October 10, 2023

RE: CMD Ellicott Pump Station - Development Plan - PPR2334

I am in receipt of a referral request for comments for the Cherokee Metropolitan District (District) proposes to build a new process building to house new disinfection equipment and chemical storage tanks. The proposed building is located on their property at 21388 Highway 94, Ellicott, 80808. This project also includes modifications to their existing water storage tank, as well as improvements to the existing water storage tank and construction of a new, 500,000-gallon water storage tank. The new tank will be on property acquired through a land swap agreement with the adjacent Mayberry development, for which negotiations are in progress. A driveway access easement from Cattlemen Run via Springs Road will be included in the agreement. The property has the tax schedule No. 3414201027 on approximately 1-acre at the north central quarter of Section 14, Township south, Range 63 west of the 6th P.M., County of El Paso, State of Colorado. After review of all documentation, we have the following comments:

SHEET NO.
C1.0

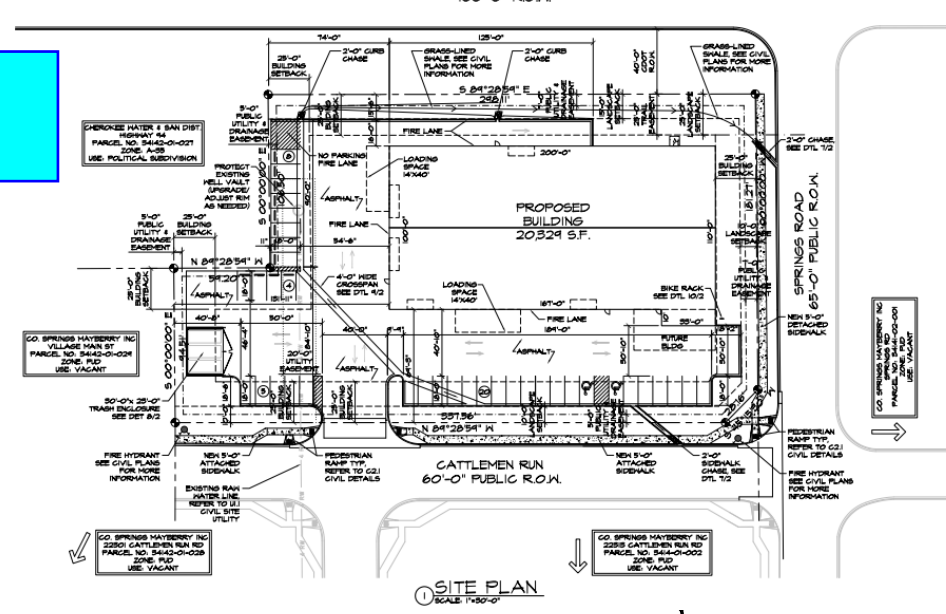
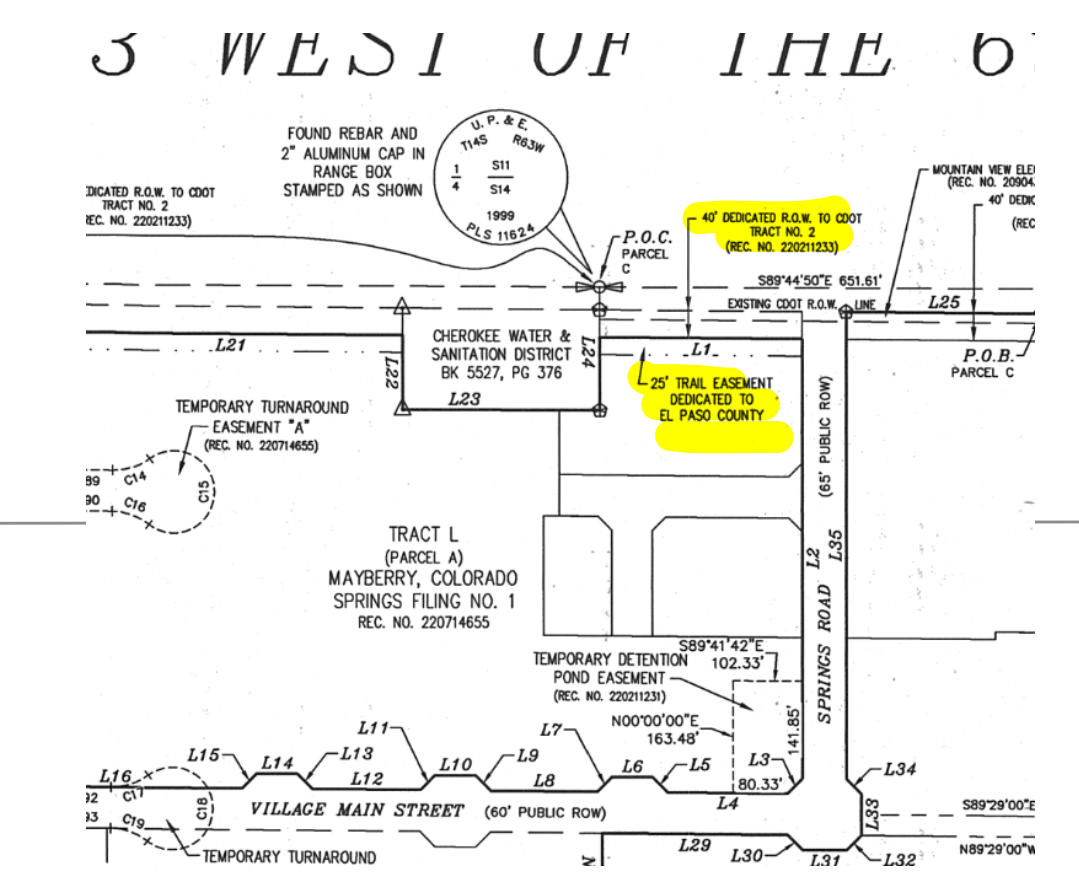
- **A CDOT Access Permit will be required for this development to close the access along SH94 since access is to be gained from Business Park Ave.**
- **A Secondary access permit is required to document the relocation of access to Business Park Ave cul-de-sac.**
